## DEPARTMENT OF PARKS AND COMMUNITY SERVICES

February 28, 2023

**Subject: Grandview Reserve 1041 Permit Application Review, 2<sup>nd</sup> Submittal – (AASI-21-003)**

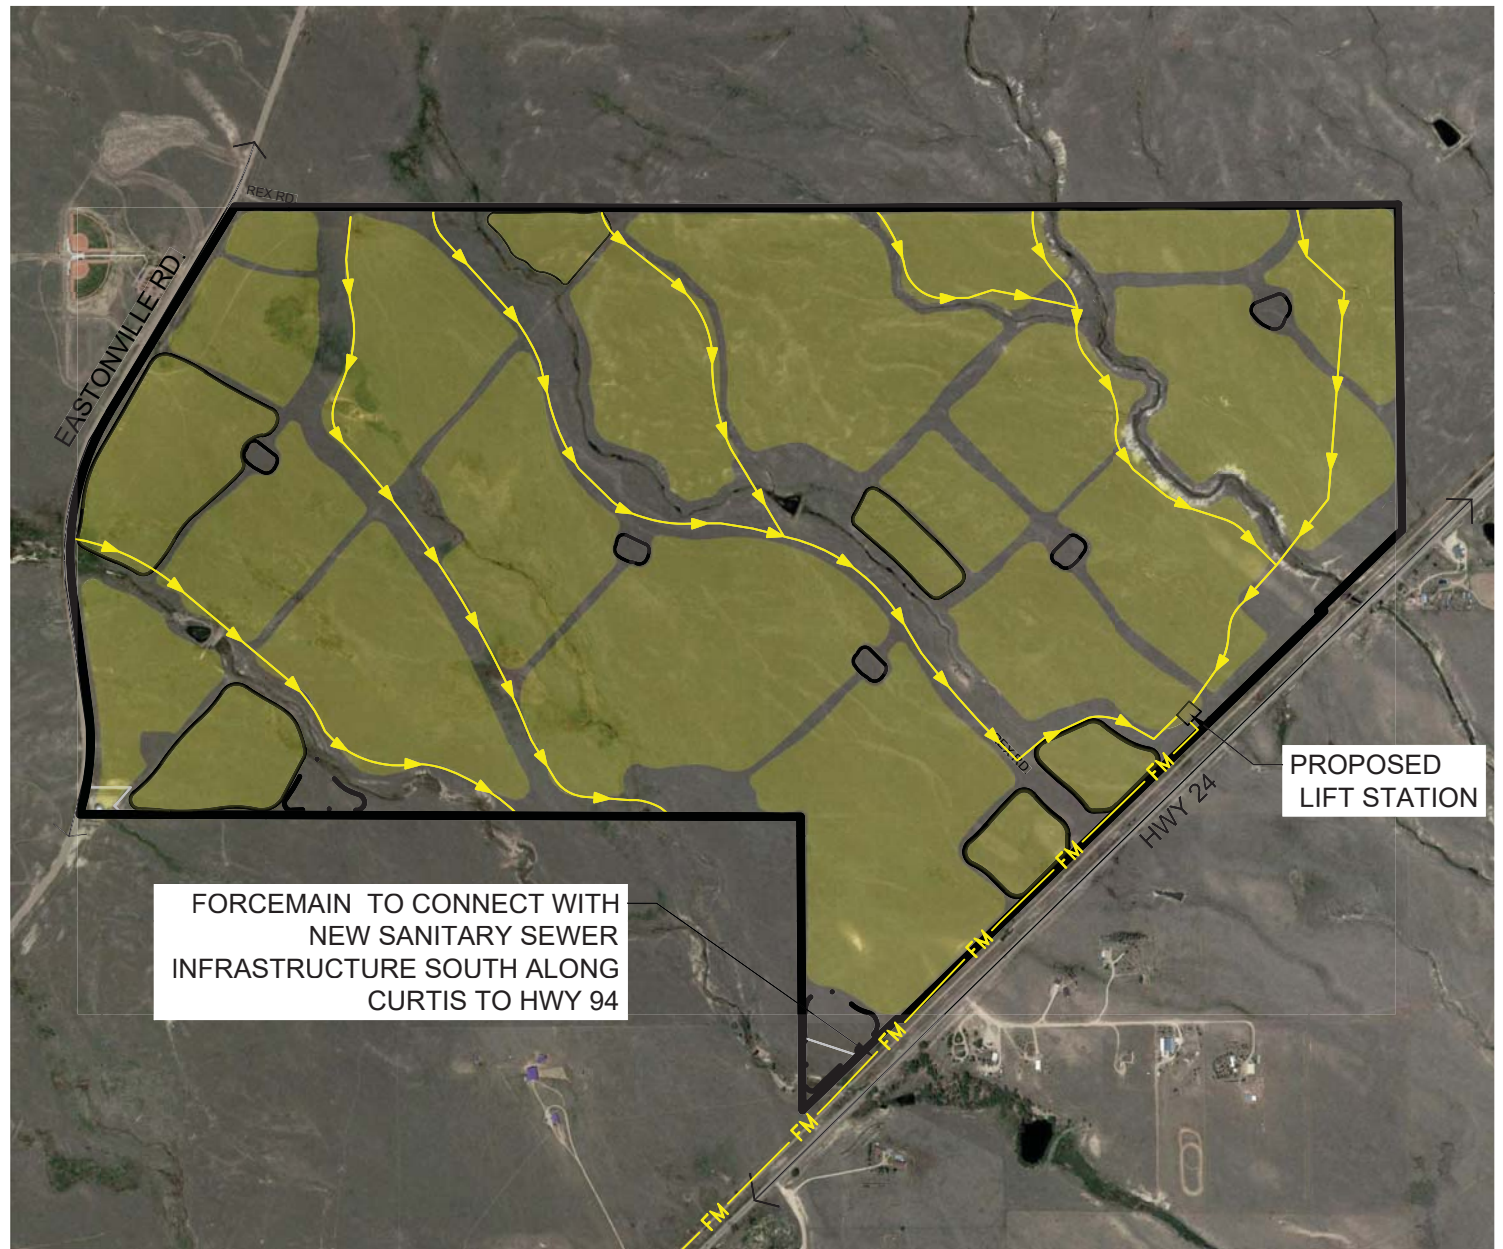
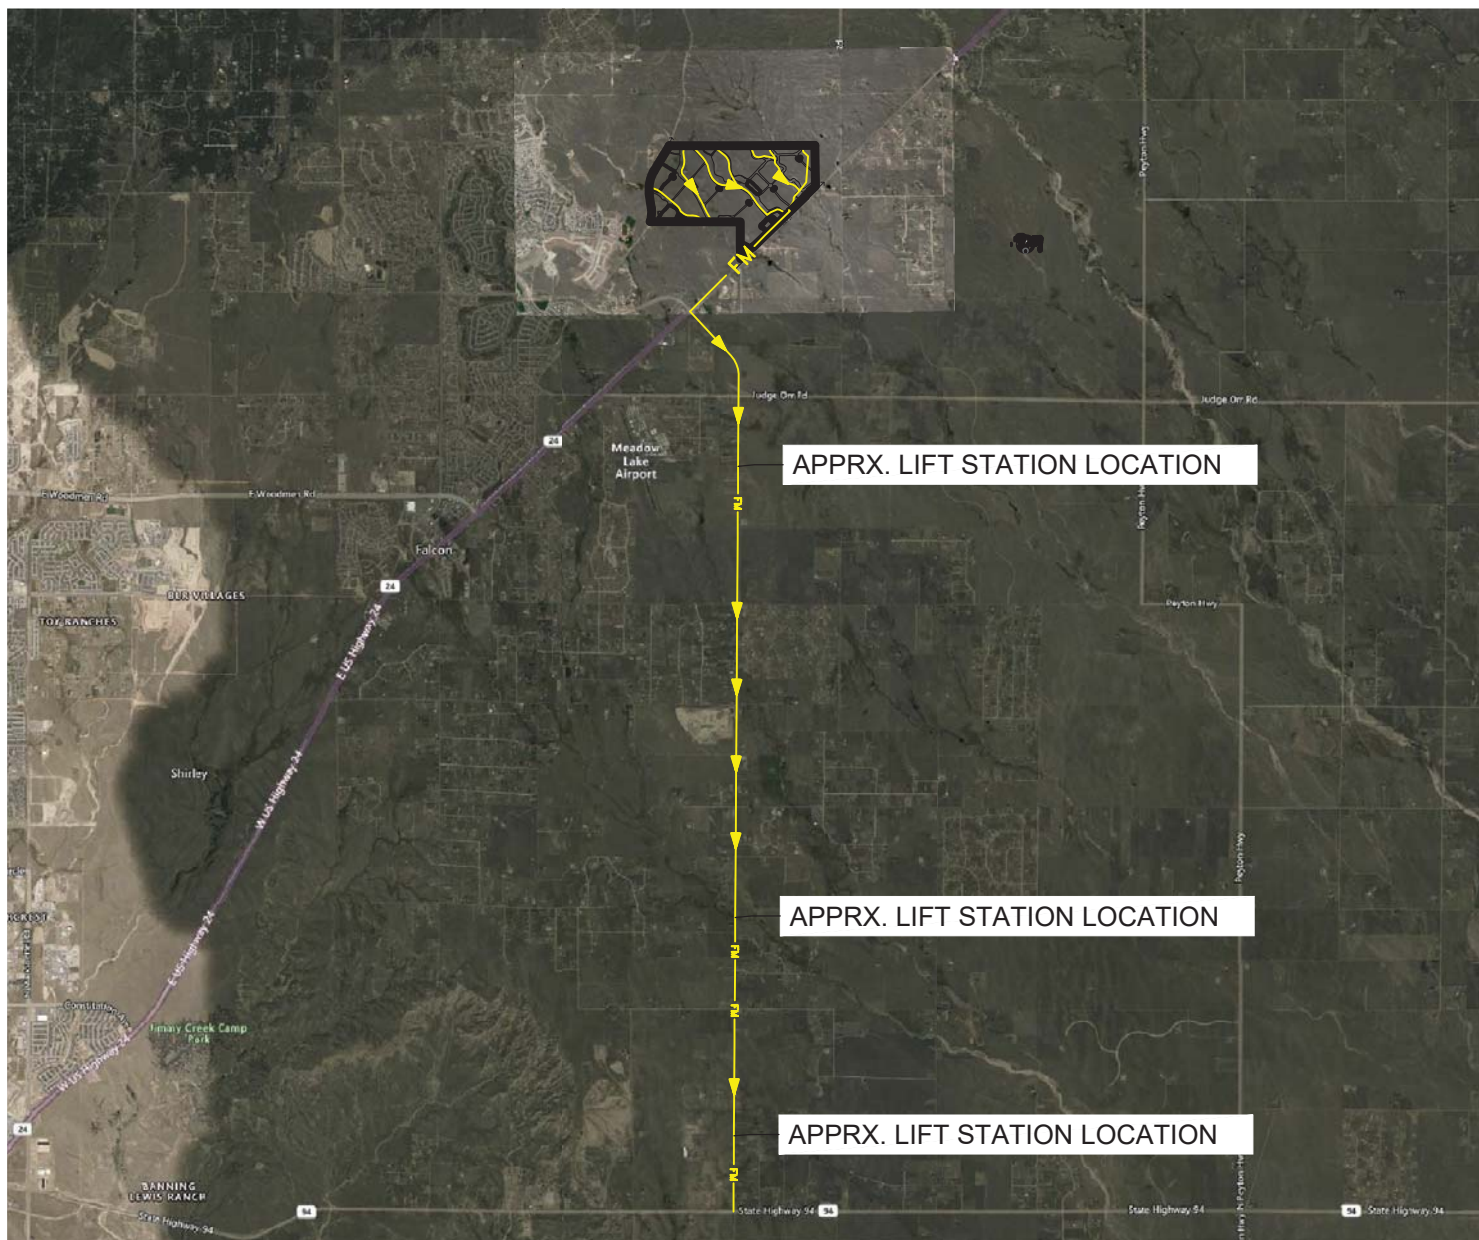
However, the proposed sanitary sewer lines, as depicted in the submitted schematic of the three sewer line alternative routes, will impact the existing Rock Island Primary Regional Trail, located immediately southeast of Grandview Reserve along East Highway 24. As noted above, the Rock Island Trail and its associated infrastructure along the site of the former Chicago, Rock Island, and Pacific Railroad has been recognized as historically significant by History Colorado, Office of Archaeology Historic Preservation, and is a major regional trail corridor, extending approximately 8.75 miles from the Town of Falcon to the Town of Peyton.

The applicant has expressed their intent to request an utility easement within the Rock Island Regional Trail corridor property, which is owned in full by El Paso County Parks, for the purpose of constructing a sanitary sewer line from Grandview Reserve to various termini along East Highway 24, depending on the chosen sewer line route. When the sanitary sewer line easement request is submitted in full, El Paso County Parks staff will review the plans and application and determine whether a non-exclusive permanent easement agreement can be issued for the construction of the sanitary sewer line.
